City of Portland, Maine - Building or Use Permit

Permit No: 10-1016	Date Applied For: 08/18/2010	CBL: 409 G009001
-----------------------	---------------------------------	---------------------

Location of Construction: 24 NOTTINGHAM AVE	Owner Name: DOBSON DANIEL & HEIDI DOB	Owner Address: 24 NOTTINGHAM AVE	Phone:
Business Name:	Contractor Name: Property Owner	Contractor Address: Portland	Phone:
Lessee/Buyer's Name	Phone:	Permit Type: Additions - Duplex

Proposed Use: Single Family Home - Addition of porch on 2 sides of main house	Proposed Project Description: Addition of porch on 2 sides of main house
--	---

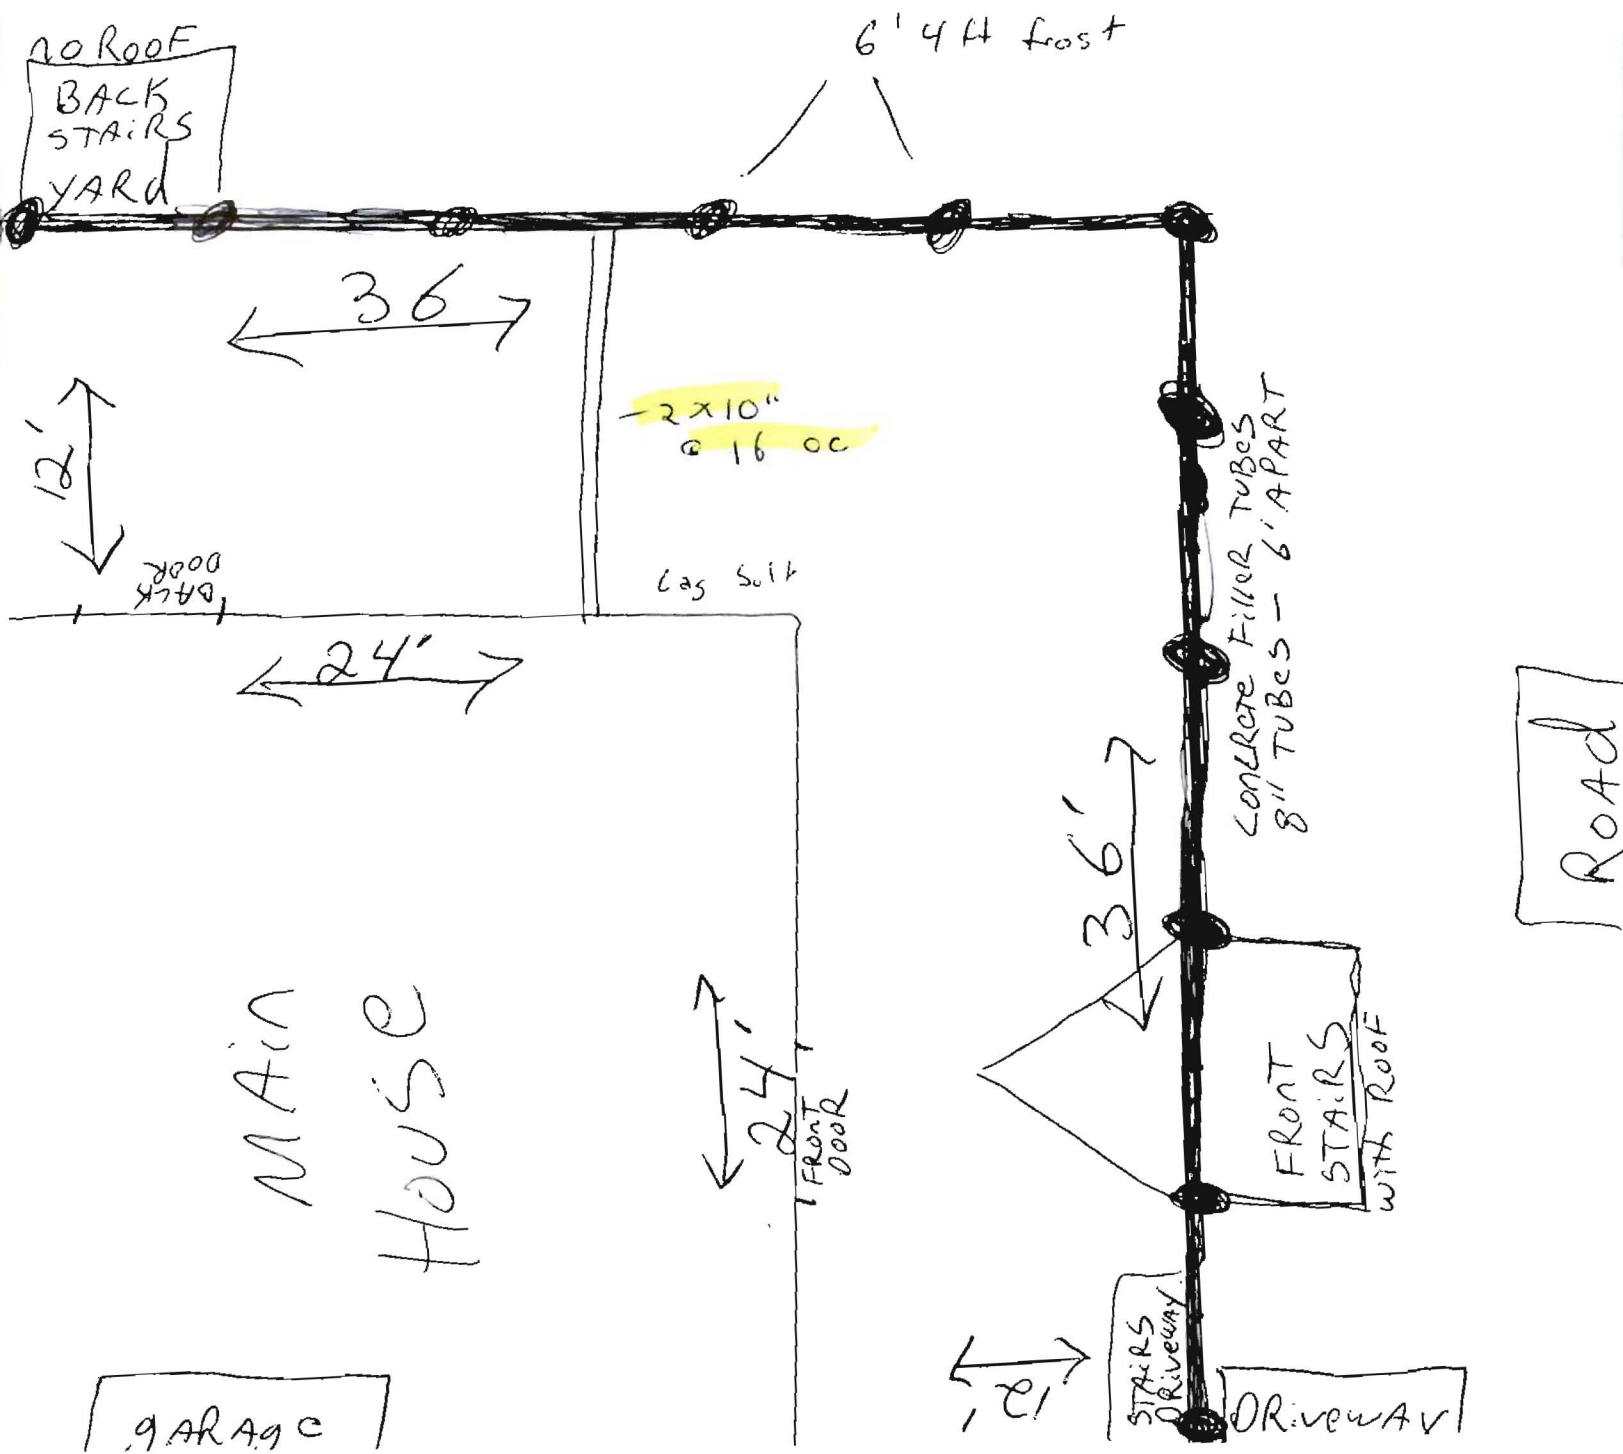
9/15/2010-jrioux: Revised plan with Owner, he chose to use 2X10 @ 16 O/C floor joist, with triple 2X10" beam resting- to 8" Sona tubes every 6"; dimensions for fall protection and graspable handrail details were given to Owner; the floor joist will not be cantilevered.

BOUNDARY/EXISTING CONDITIONS PLAN AT 24 NOTTINGHAM AVENUE, PORTLAND, MAINE

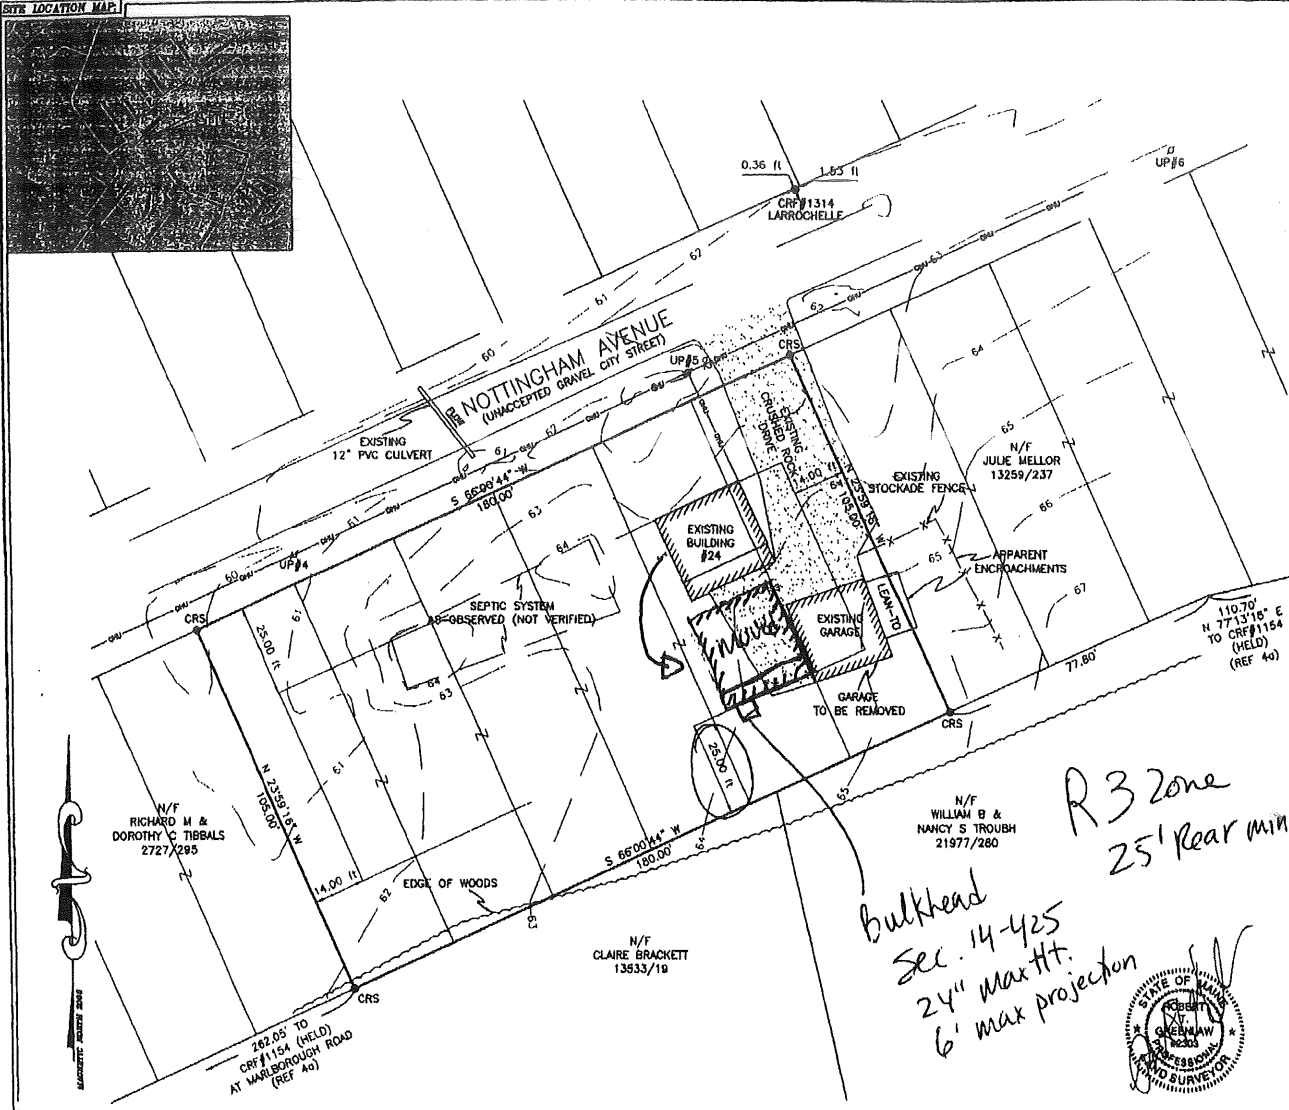
8/24/2010-mes: I can not tell wher the deck is going based on the two sides of the house based on what was submitted - I will call owner - the plans are pretty sketchy as to where the house was moved.

8/27/2010-mes: owner came in today and drew on his plans where the the new deck was going - front and side
